RATL Residents Around Thomson Lane Inc.

3rd April, 2019

In relation to the proposed SCEGGS Masterplan (Over) Development which is currently on exhibition on the major projects website

Thomson Street Elevation - Existing Envelopes

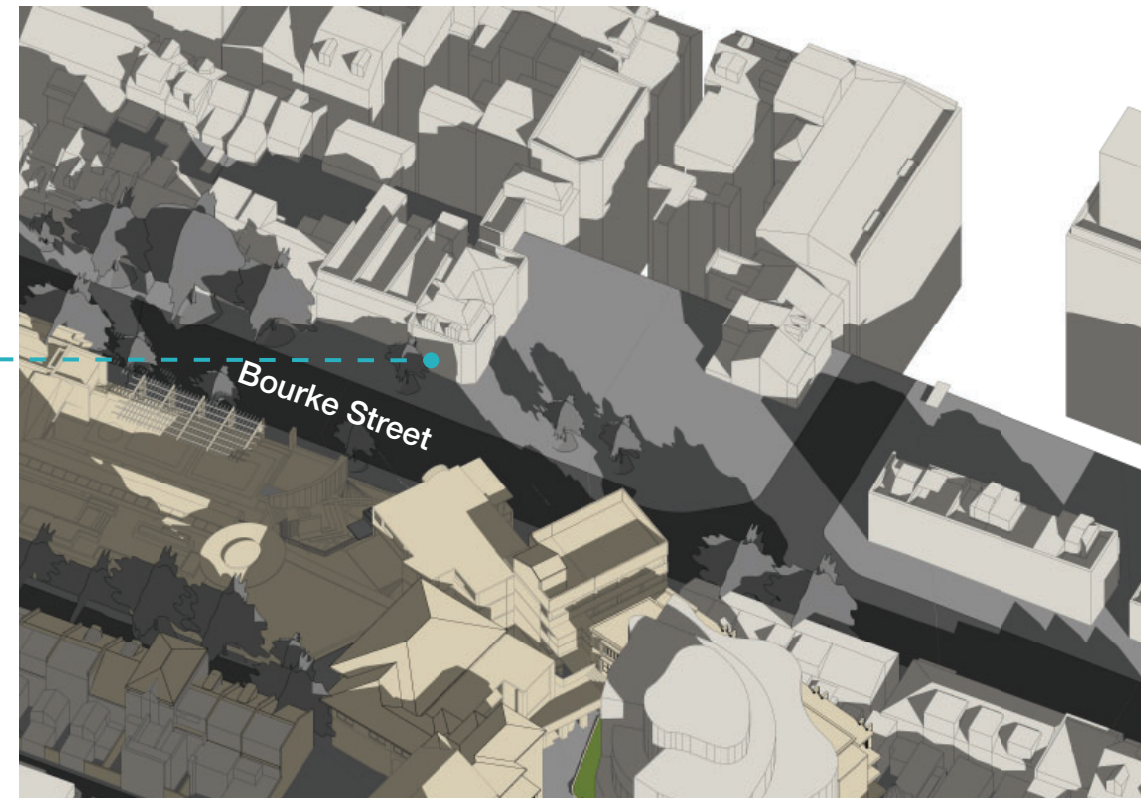
1/ The height of the proposed new Multipurpose Building at RL 53.0 is between 1.4 metres and 2.8 metres higher than sections of the existing Old Gym Building, which is located on that part of the SCEGGS School site. This will cause unacceptable view loss

impacts from either an entire storey or half a storey of the twelve Forbes Street houses from number 231 to 253, which currently have generally unobstructed views of the Sydney Harbour Bridge through the existing view corridor over the upper part of the SCEGGS school site. The only way in which this adverse view loss impact can be avoided is by reducing the proposed new building height by an entire storey, from RL 53.0 m to RL 50.2 m

8 Privacy and Overlooking

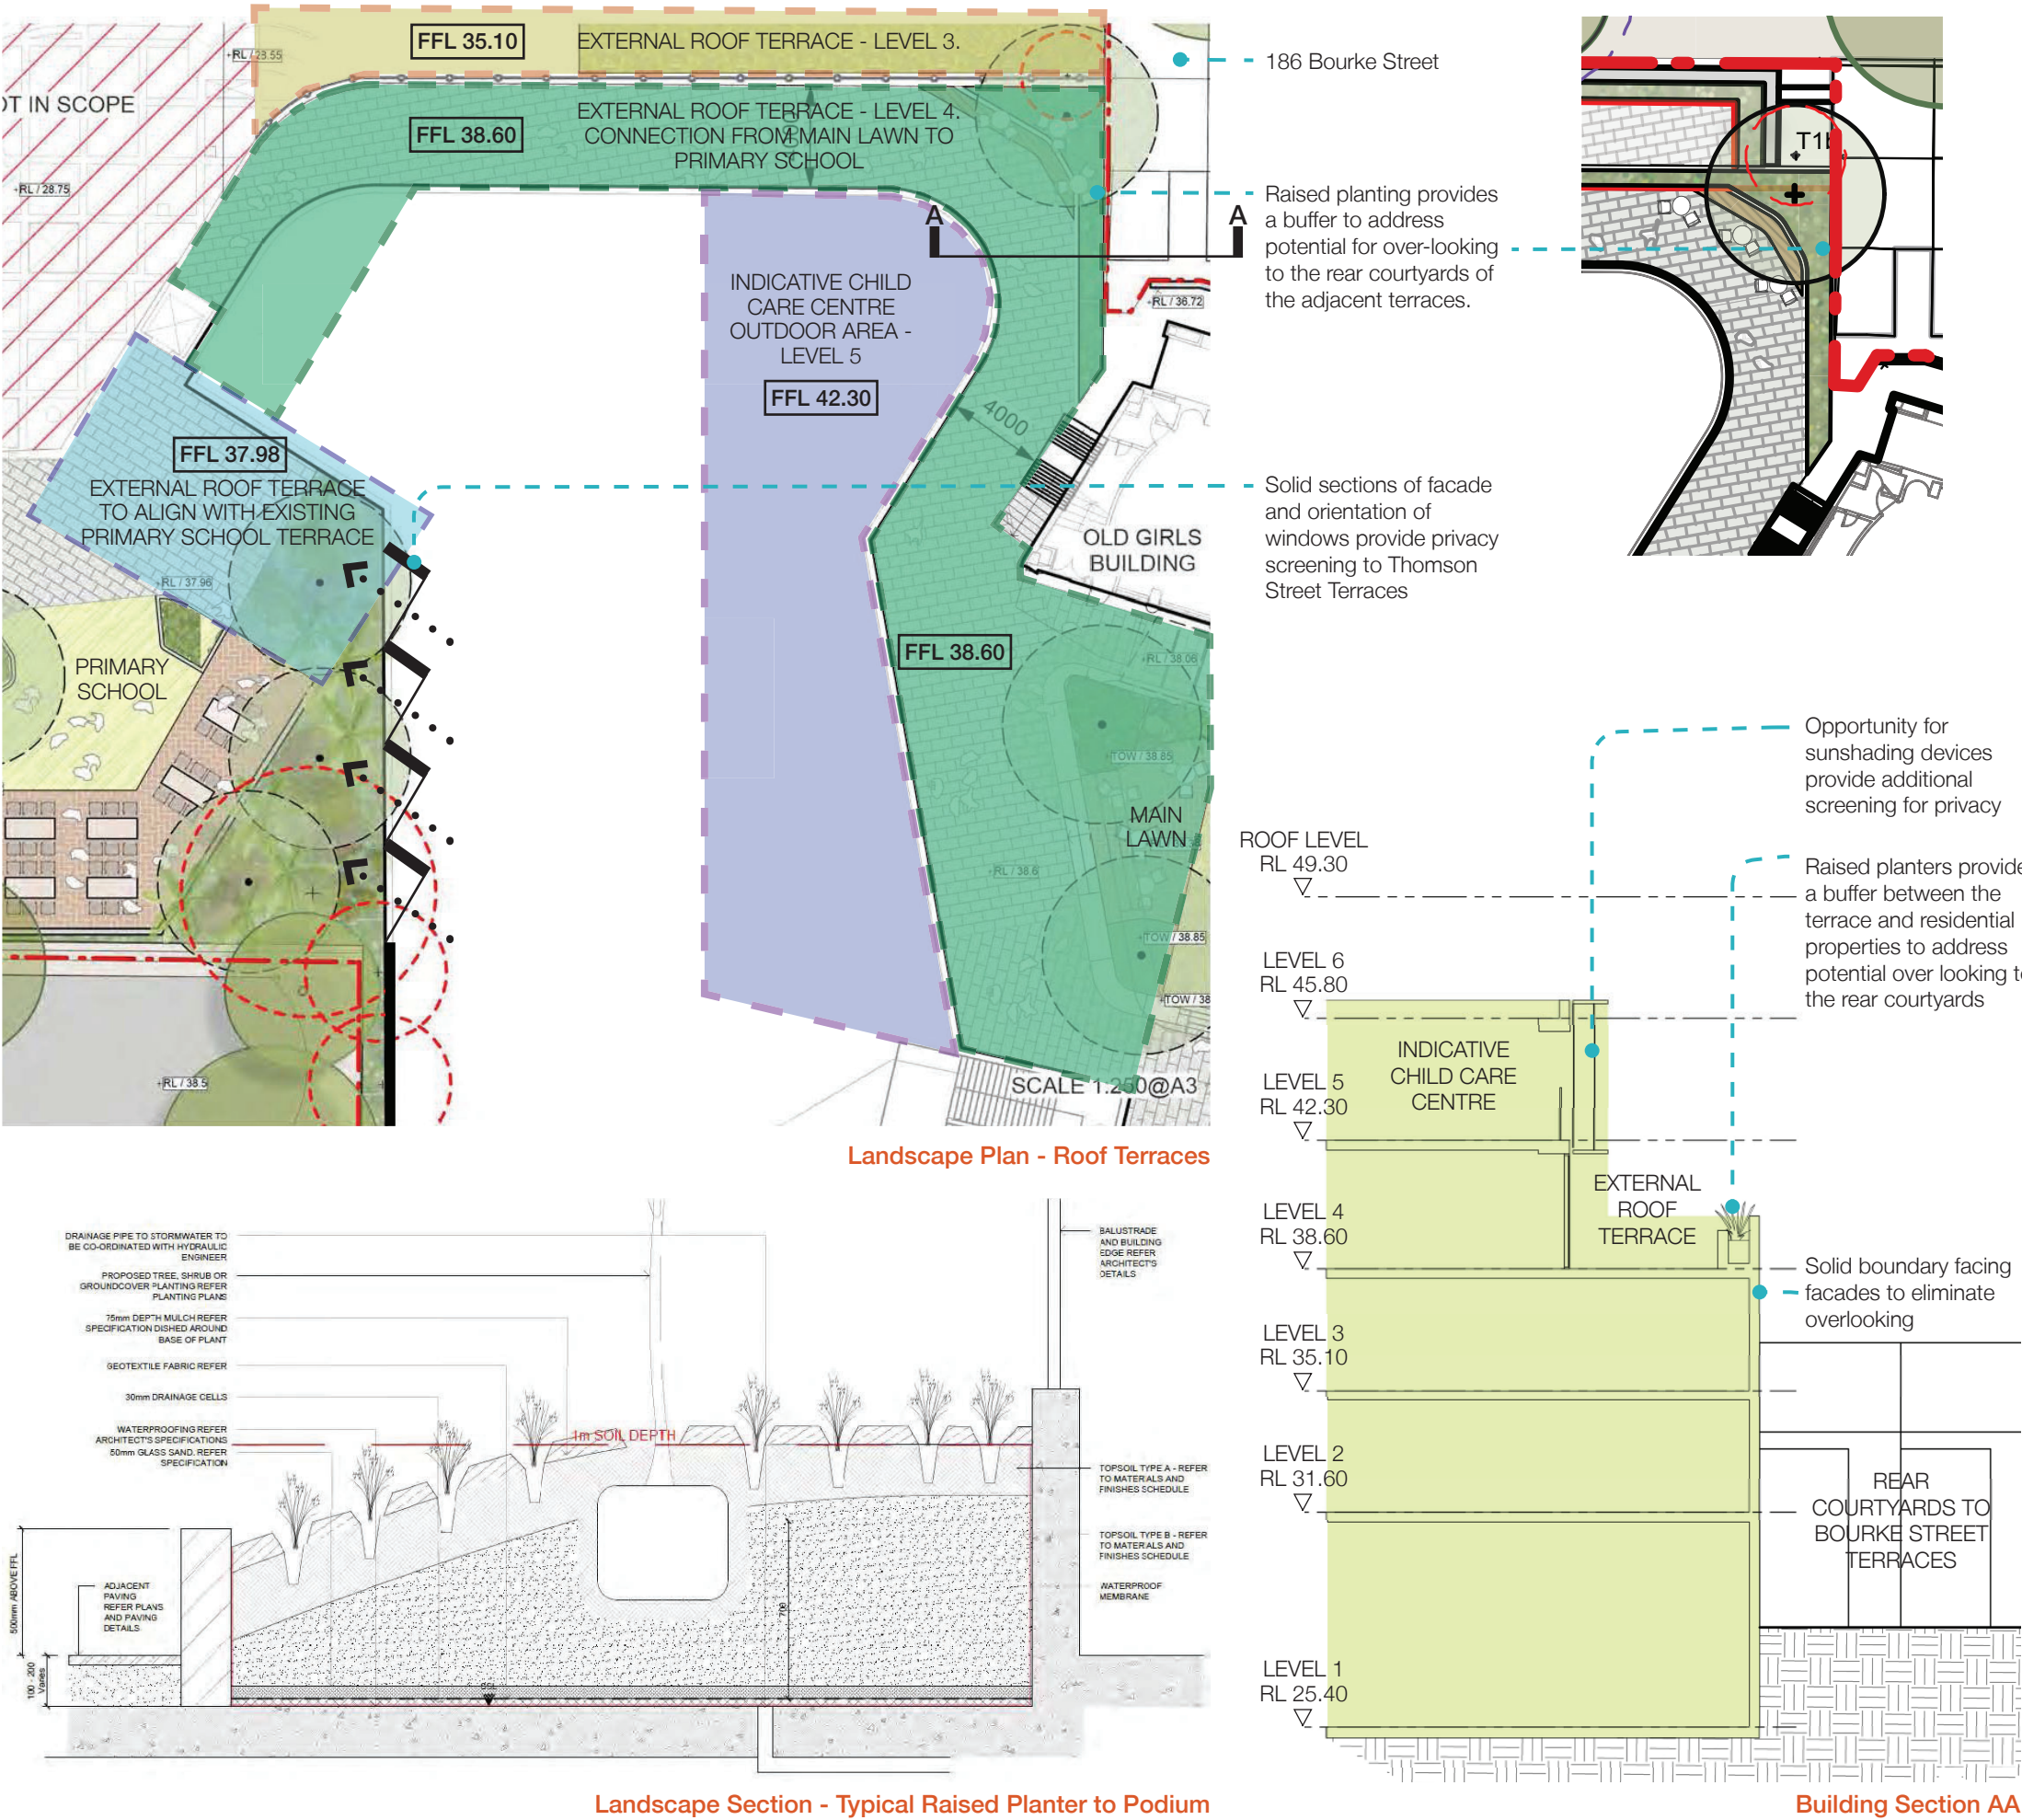
2/ The design of the seventh storey (rooftop level) of the proposed multi purpose building appears to include outdoor areas, which could be used for school functions/receptions or other potential noise generating uses. Any assessment of the acceptability of this building in terms of its height and other impacts for neighbouring residents, must also consider all potential uses for this level of the building.
